Ribble Valley Borough Council
Planning Section
Council Offices
Church Walk
Clitheroe
BB7 2RA

Planning Application No: 3/2022/0350

Proposal: Proposed rear two storey extension and single storey porch to front.

Location: 8 Whipp Avenue, Clitheroe BB7 2QA

**Drawing No;** P100 - 20/04/22

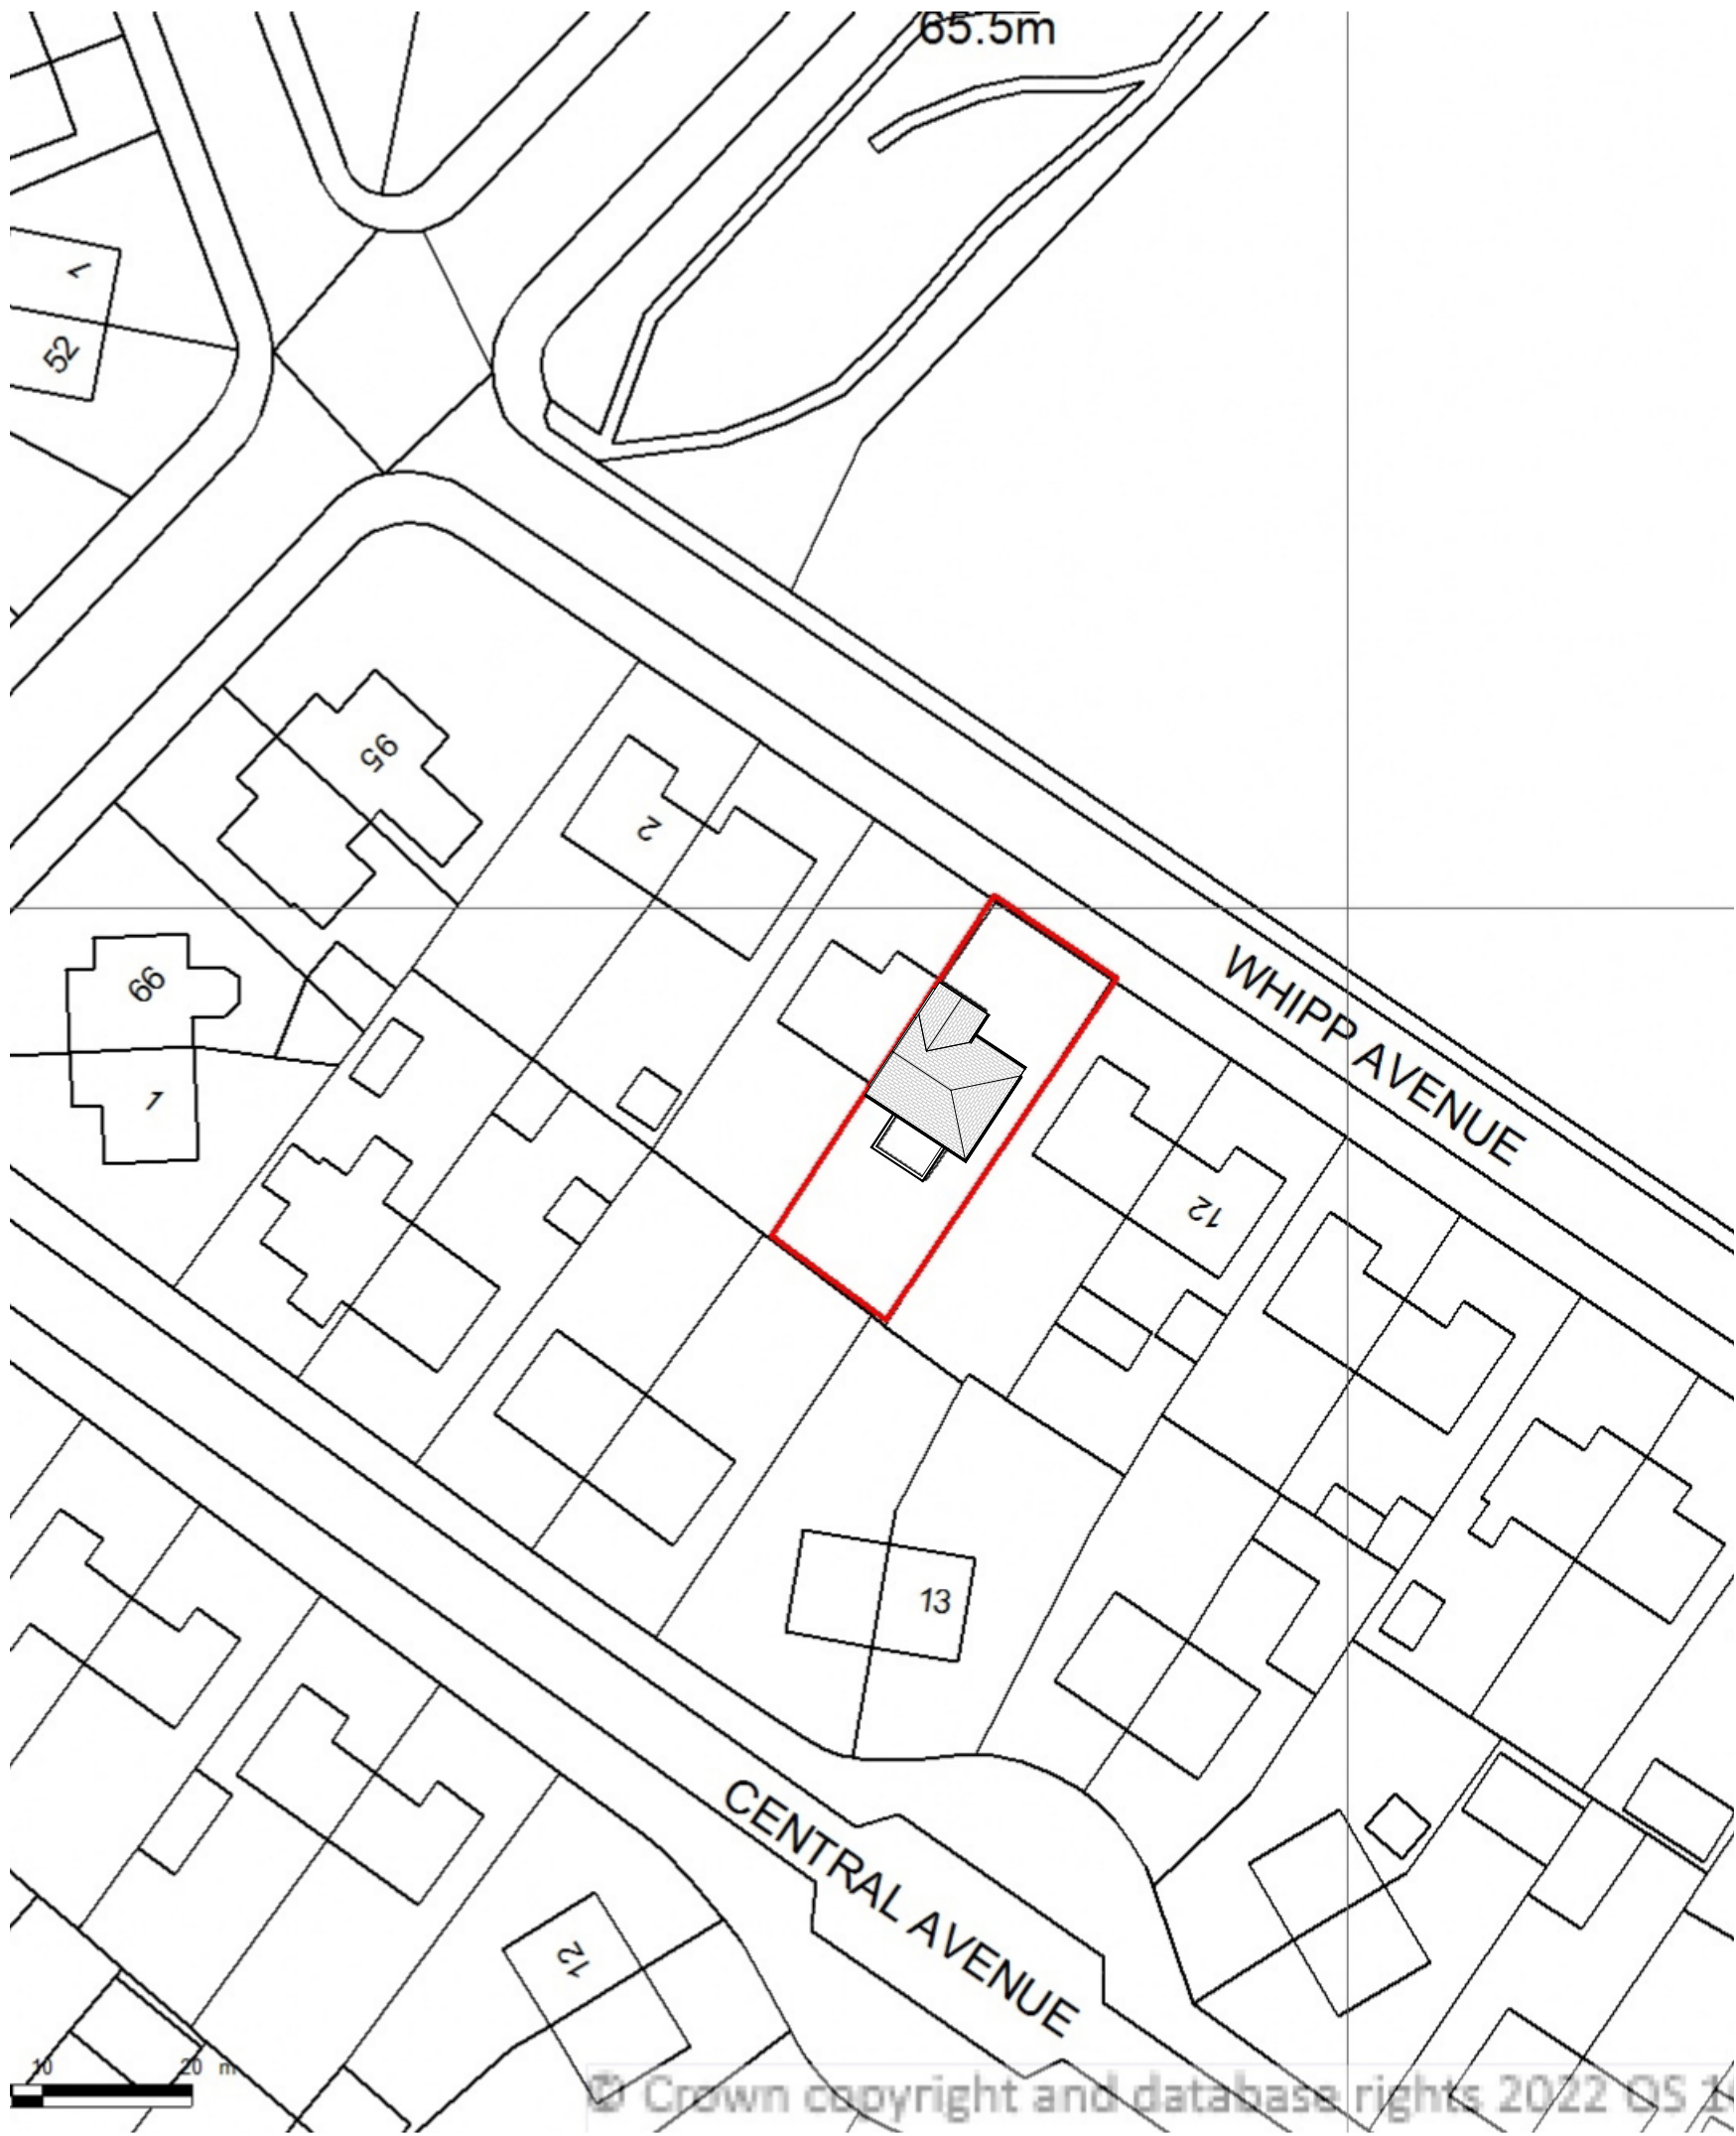
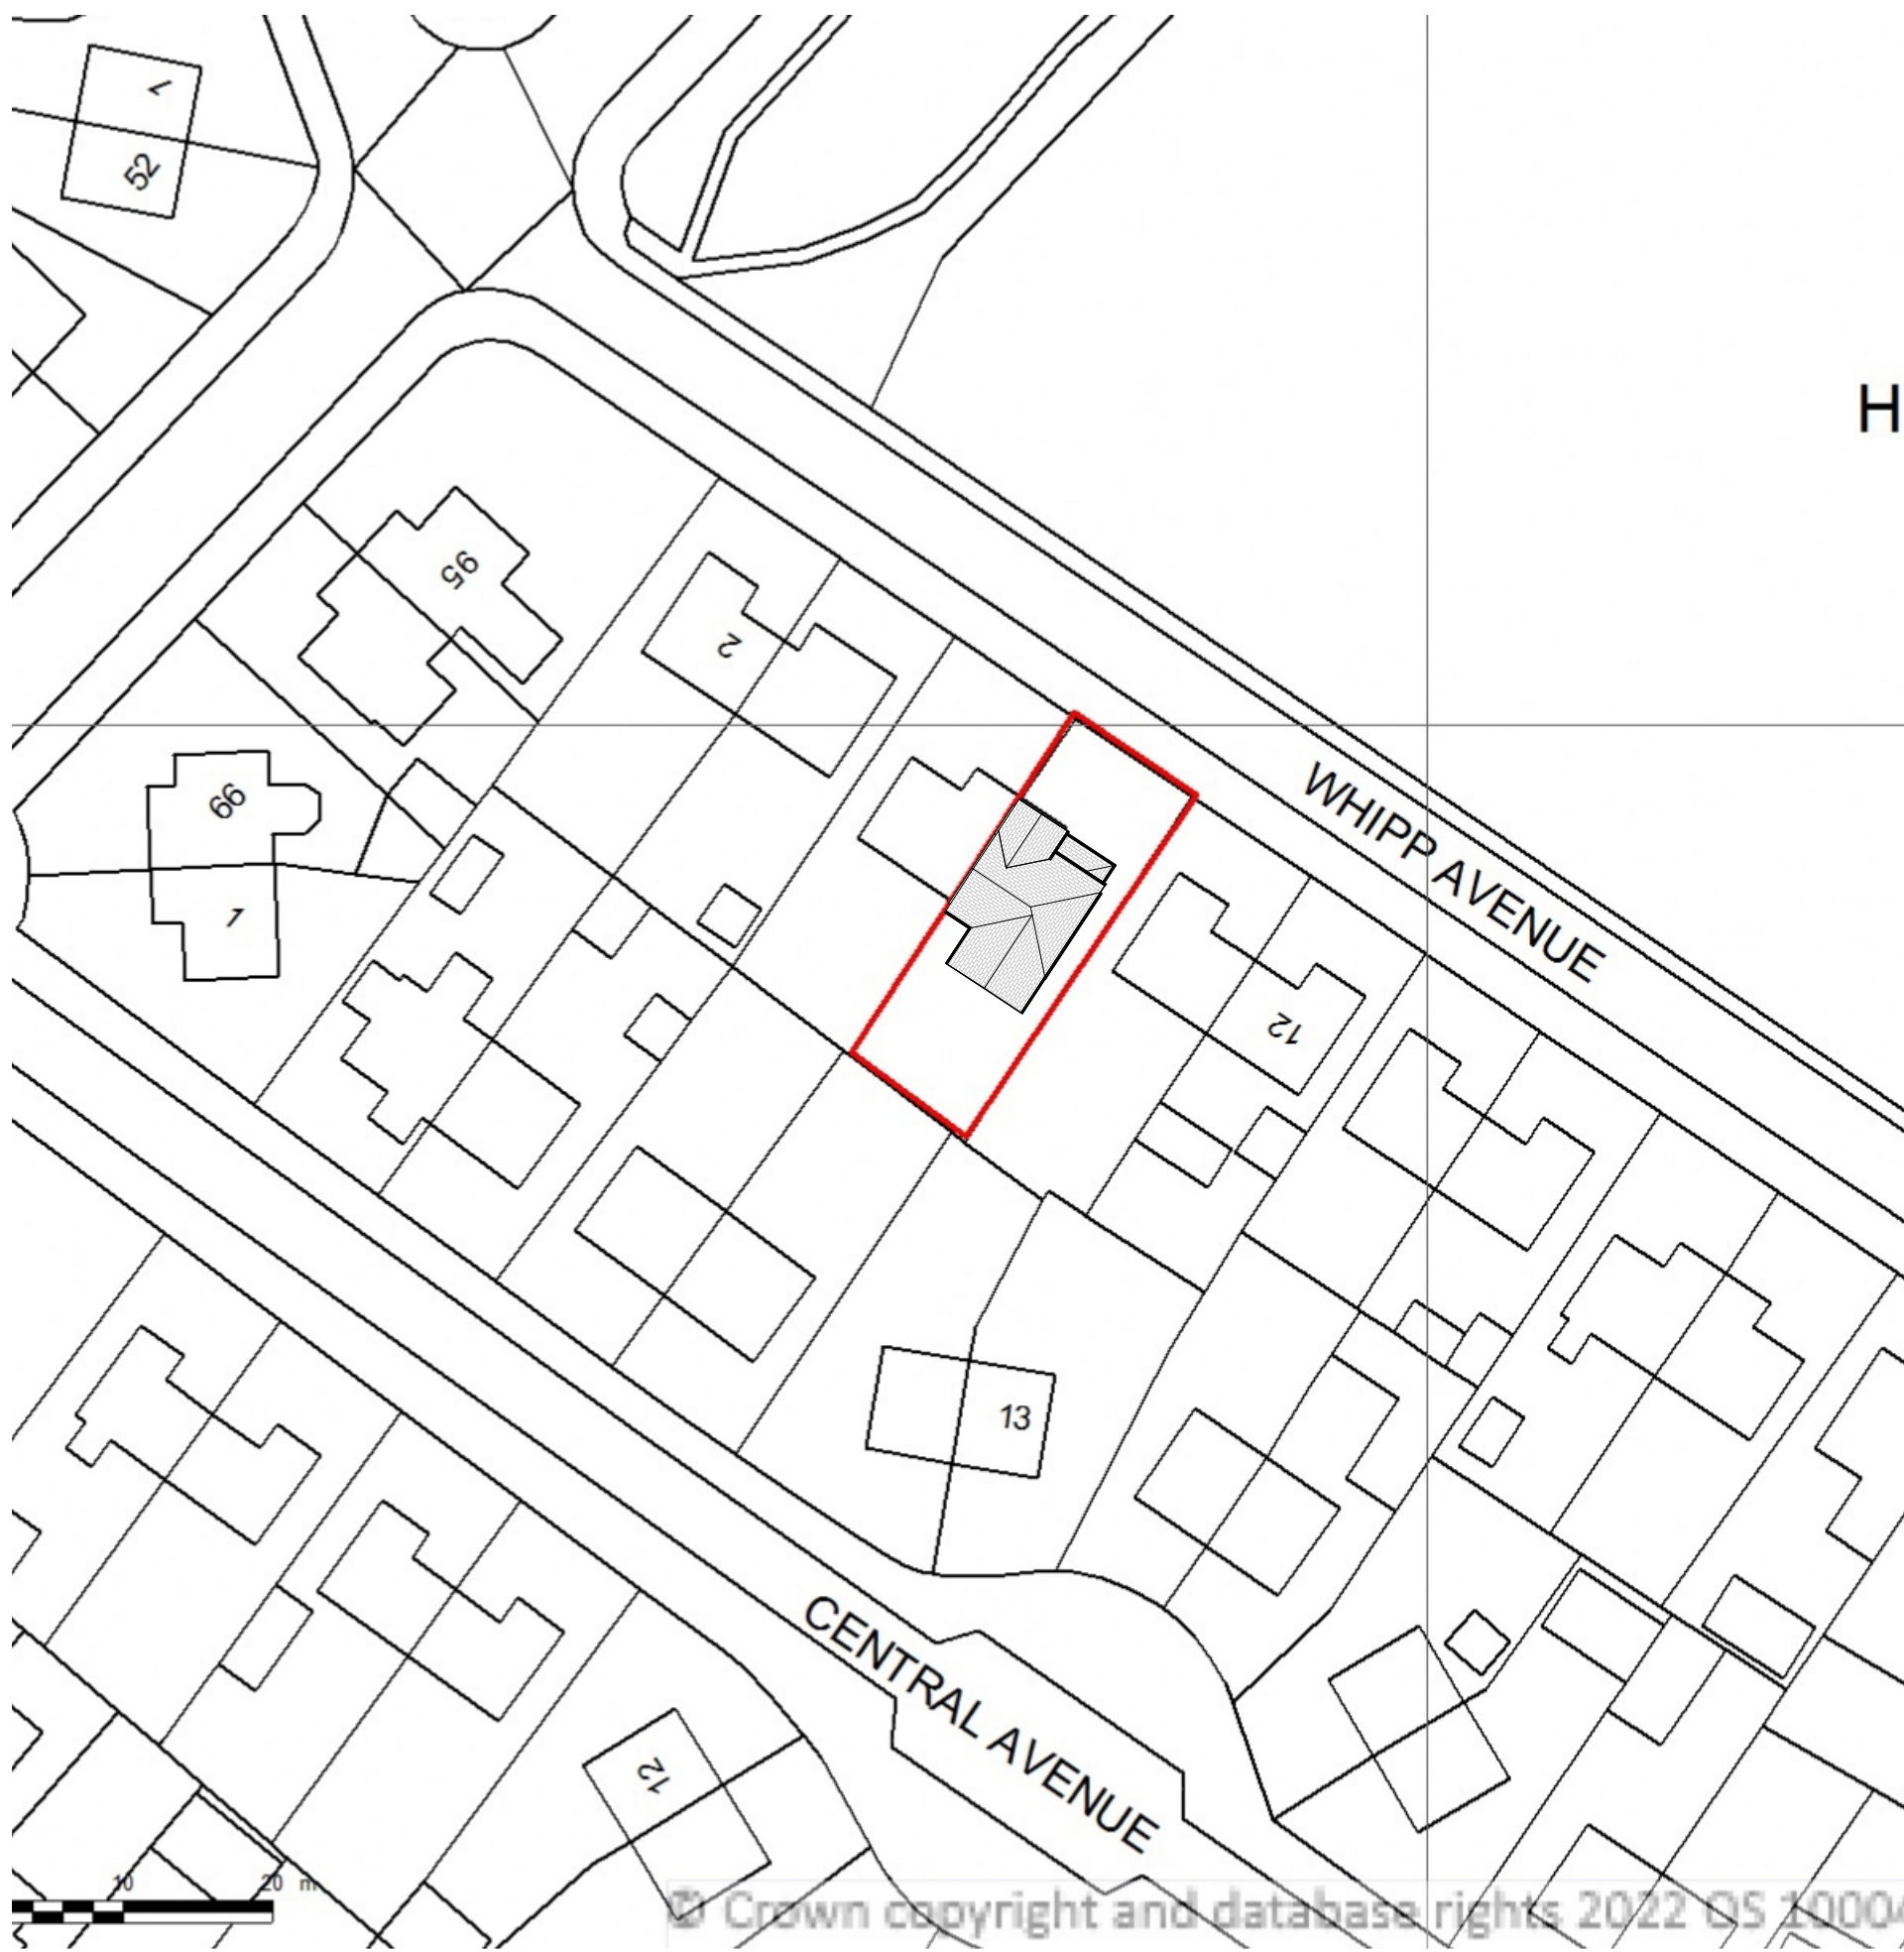
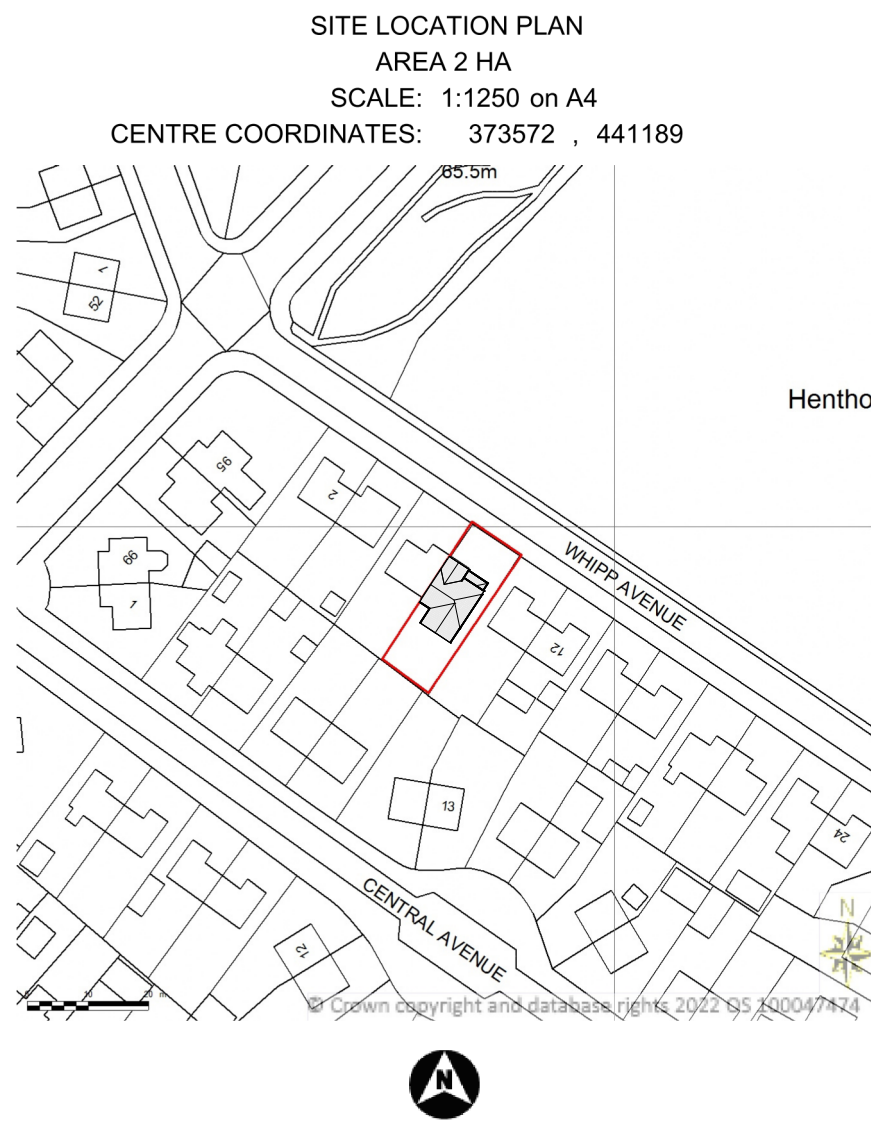
A car parking plan should be submitted showing the existing off-road parking provision plus that proposed. From a desk top analysis there is currently only one off-road parking space.

Three parking spaces would normally be required for a property with four bedrooms. However, if two adequately sized spaces are provided the highway authority would accept this reduction as neighbouring properties have off-road parking and there are no parking restrictions on Whipp Avenue. Therefore, any on-road parking is unlikely to be detrimental to the capacity and highway safety of Whipp Avenue.

An increase to the off-road parking provision would also require the widening of the existing dropped vehicle crossing so that vehicles can enter and leave independently. This work would need to be carried out under a legal agreement (Section 171) with Lancashire County Council as the highway authority.

The extended driveway/hardstanding should be surfaced in a bound porous material to prevent loose surface material from being carried onto the adopted highway network where it could pose a hazard to other highway users.

To count as two parking spaces plus provide pedestrian access the driveway should be a minimum of 5.6m wide and at least 5.6m long to prevent vehicles overhanging the adopted footway.
